CITY OF PORTLAND

RE: Forest City Chevrolet, 1000 Brighton Avenue (Site Plan #2000-0064, CBL #243-B-043)

RE: Site Plan Amendment, 1000 Brighton Avenue
Job ID#2003-0175, CBL #243-B-043

CASCO BAY TRAP

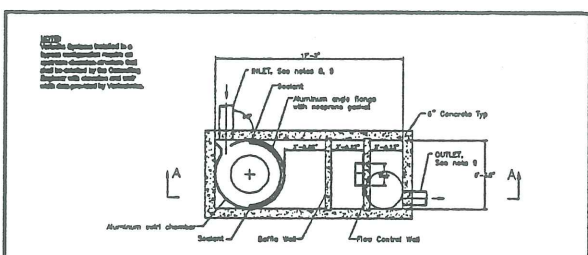
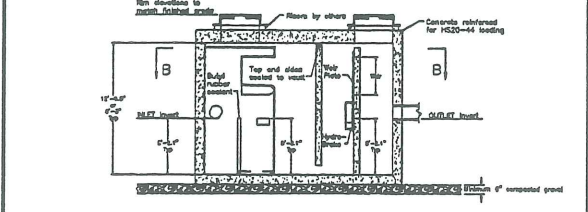
1. Stormwater calculations or analysis performed by an engineer shall be submitted stating that there is capacity in the pipe system either with or without a surcharge condition.
2. Each catch basin shall be installed with a casco trap, and the existing line to the outfall into Webb Street shall be cleaned of all and any sidentment or debris.
3. The applicant shall submit to the Planning Division and Public Works Department, an as-built, record drawing of all the drainage and utilities on the site upon completion.
4. Any work within the City's right-of-way shall be the responsibility of Forest City Chevrolet.
